**RE: State Significant Development Application SSD-70316465 1953-2109
Elizabeth Drive, Badgerys Creek (Burrah Park)**

Appendix 1A: Technical Review from Sydney Water’s consultant, Civile

Figure 10: Riparian encroachment and offsets

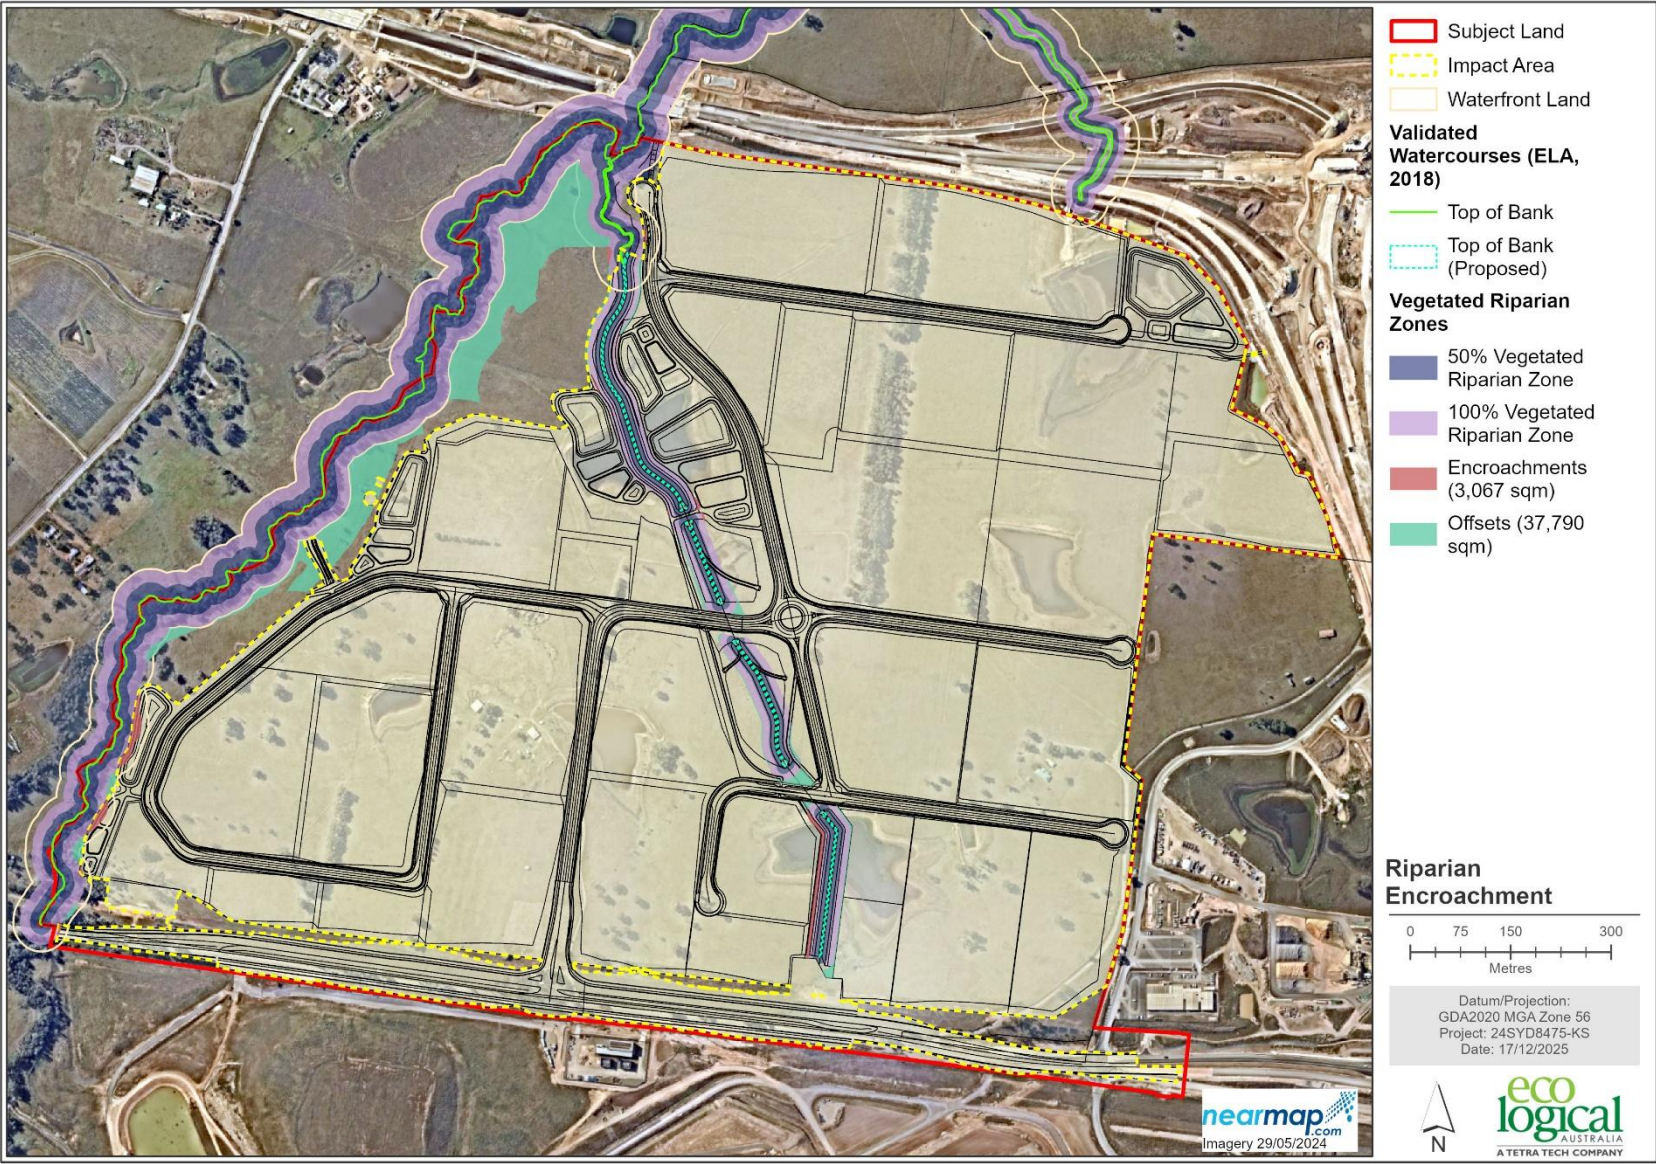
Figure 3 shows that the current design for Burrah Park has a road and roundabout encroaching into the VRZ of the remnant second order waterway. Consistent with the DCP, this waterway should be retained and rehabilitated.

The development also proposes a road link to land on the northern side of the M12. As shown in **Figure 4** this road encroaches into the VRZ of Cosgroves Creek, a fourth order watercourse.

Recommendation: That the natural waterway be retained consistent with the DCP. The alignment of the linking road be further reviewed to be consistent with the waterfront land guidelines and located outside of the 40m riparian offset.
